Subject: Plot 1 South of Highstock Lane, Gedney Hill, PE12 0QG. Details of foul & surface water disposal (Condition 3 of H07-0411-21)

Further to your correspondence dated 30th September for the above project we are pleased to respond to your queries as follows.

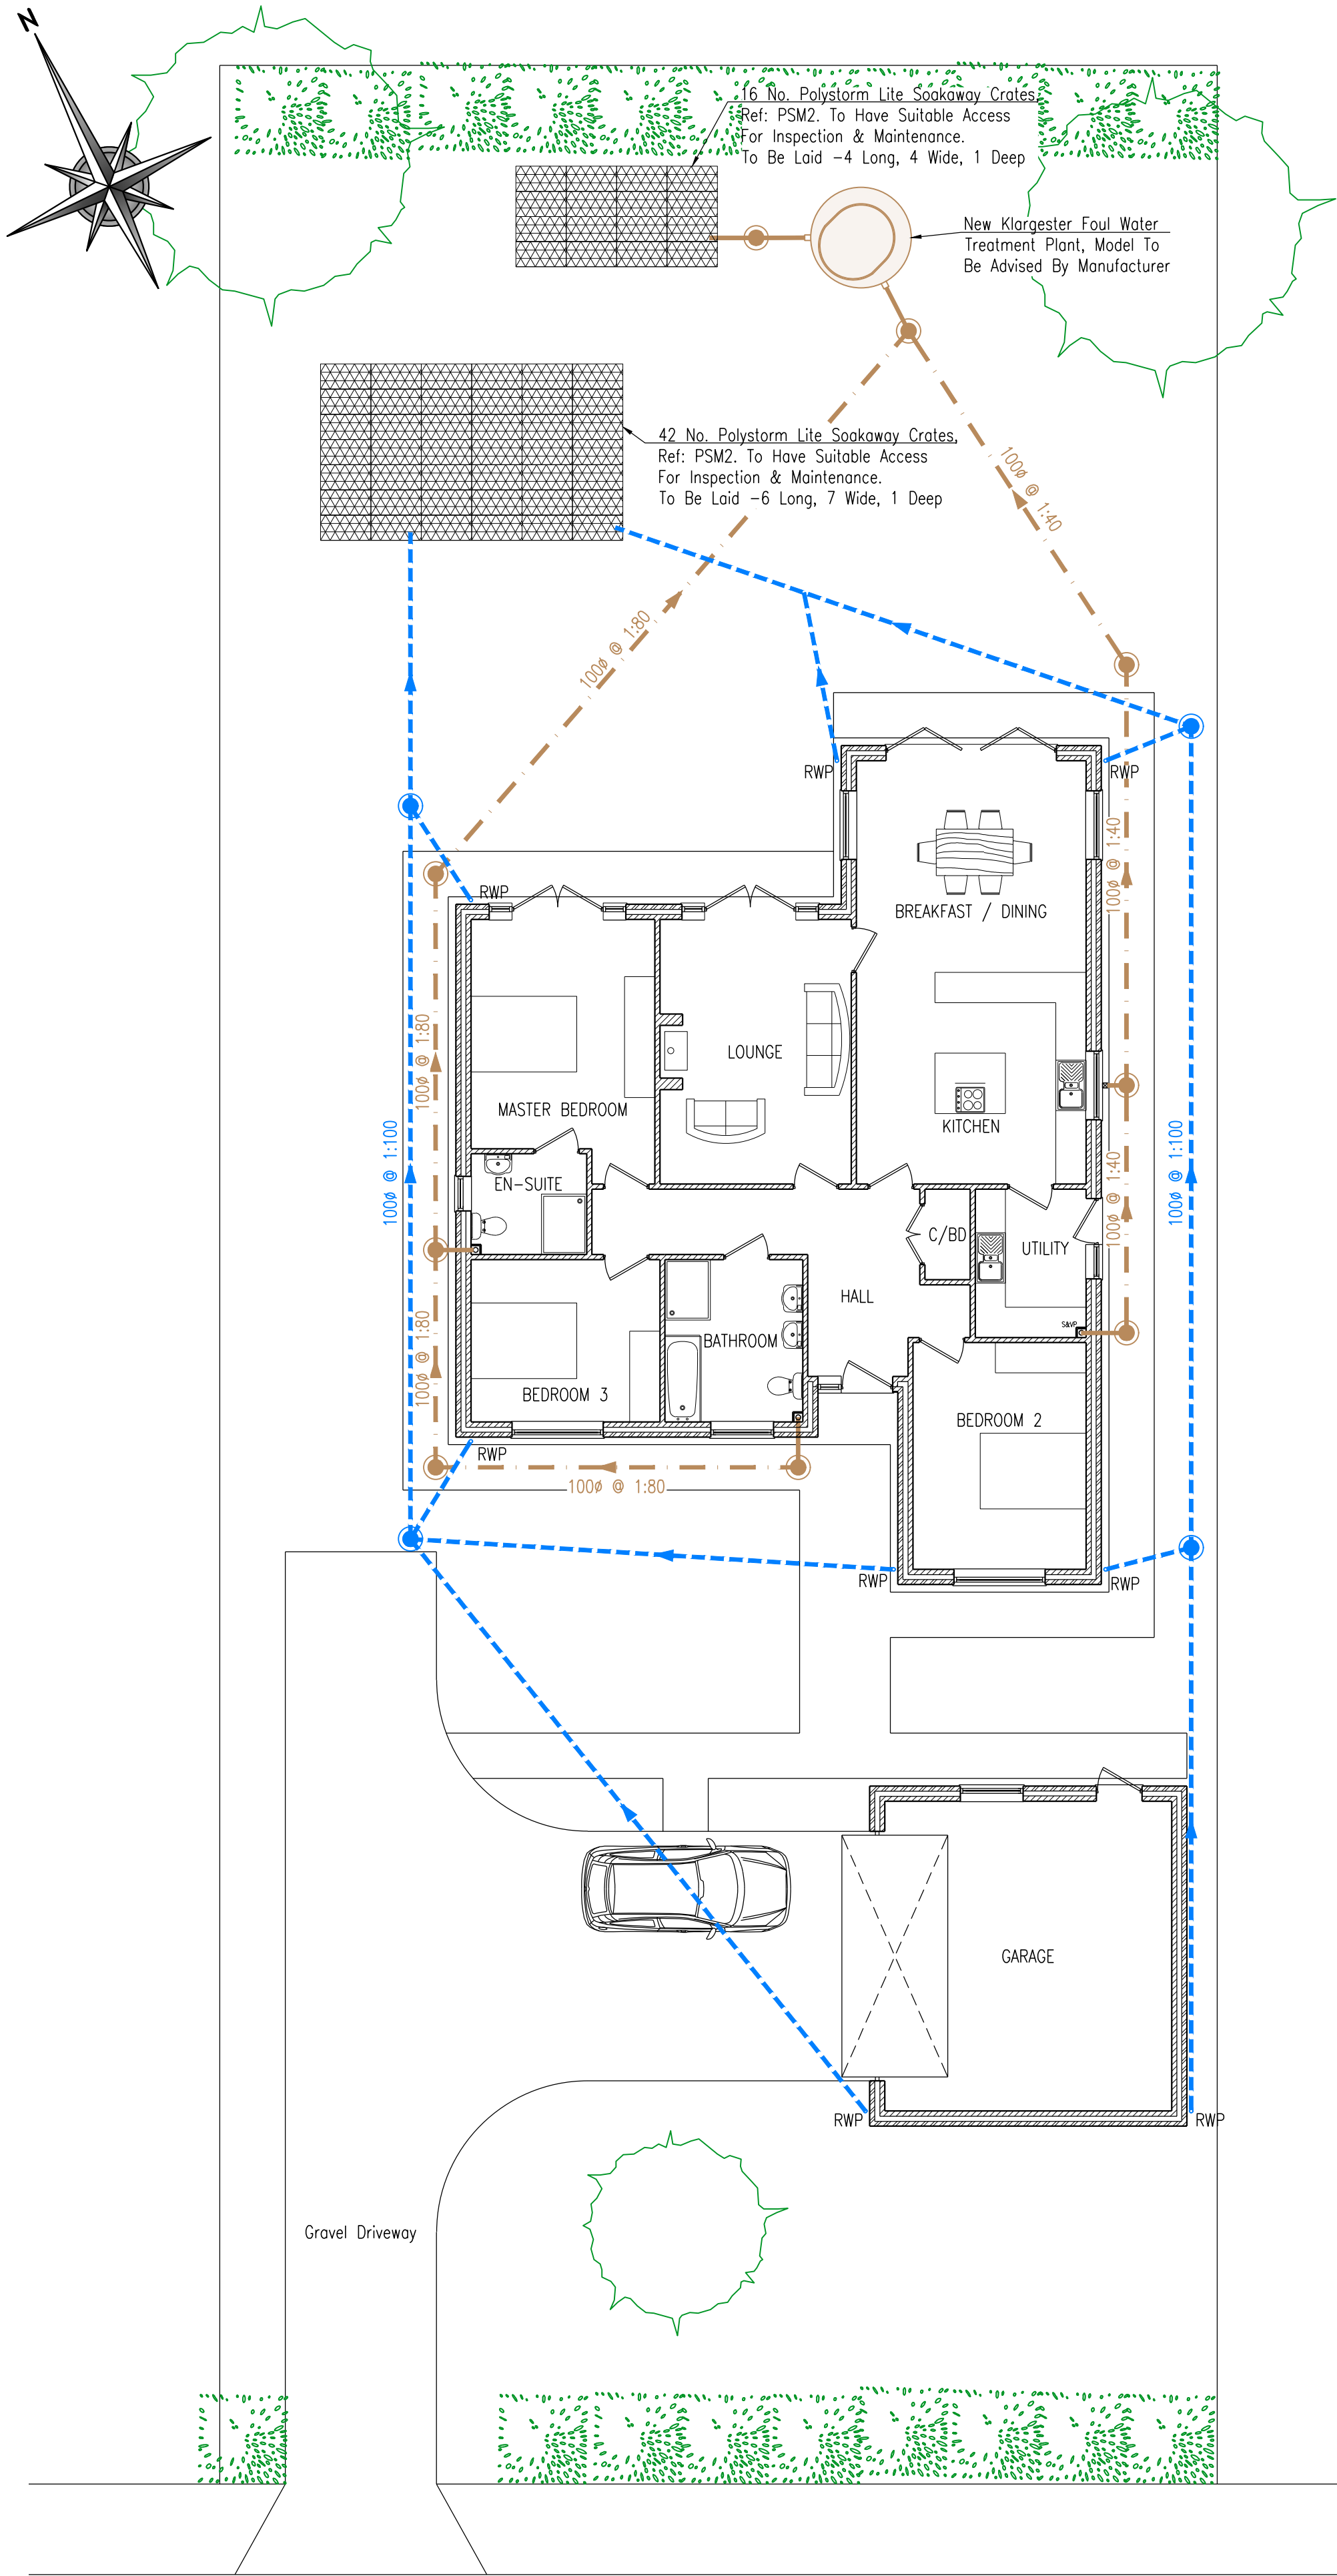
With reference to your query regarding the soakaway location, the proposed drainage arrangement is to be in accordance with our drawing 16721/01.

It should be noted that the soakaway that we are proposing is a very robust design, providing 8 cubic metres of storage.

Title
Infiltration Soak Away Sketch

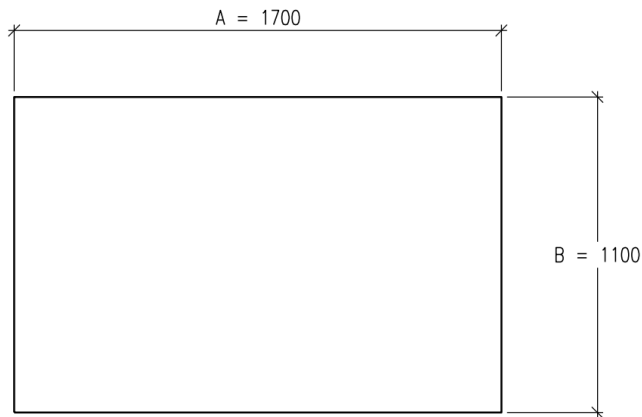
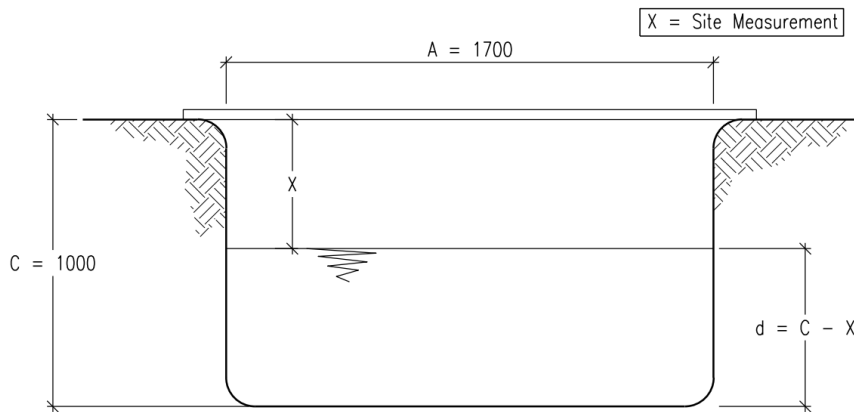
As we are sure you are aware, infiltration testing in flat low-lying fenland areas very often takes a considerable amount of time to complete. Therefore, it is rarely possible to do multiple fills of the same trial hole in a single day. This being the case, the trial hole testing would have to be undertaken on three consecutive days.

For a small one plot development site such as this, it is unfeasible/uneconomical for field testing to be carried out for this period of time. It is also, historically accepted practice in this area that a once filled trial pit is adequate.
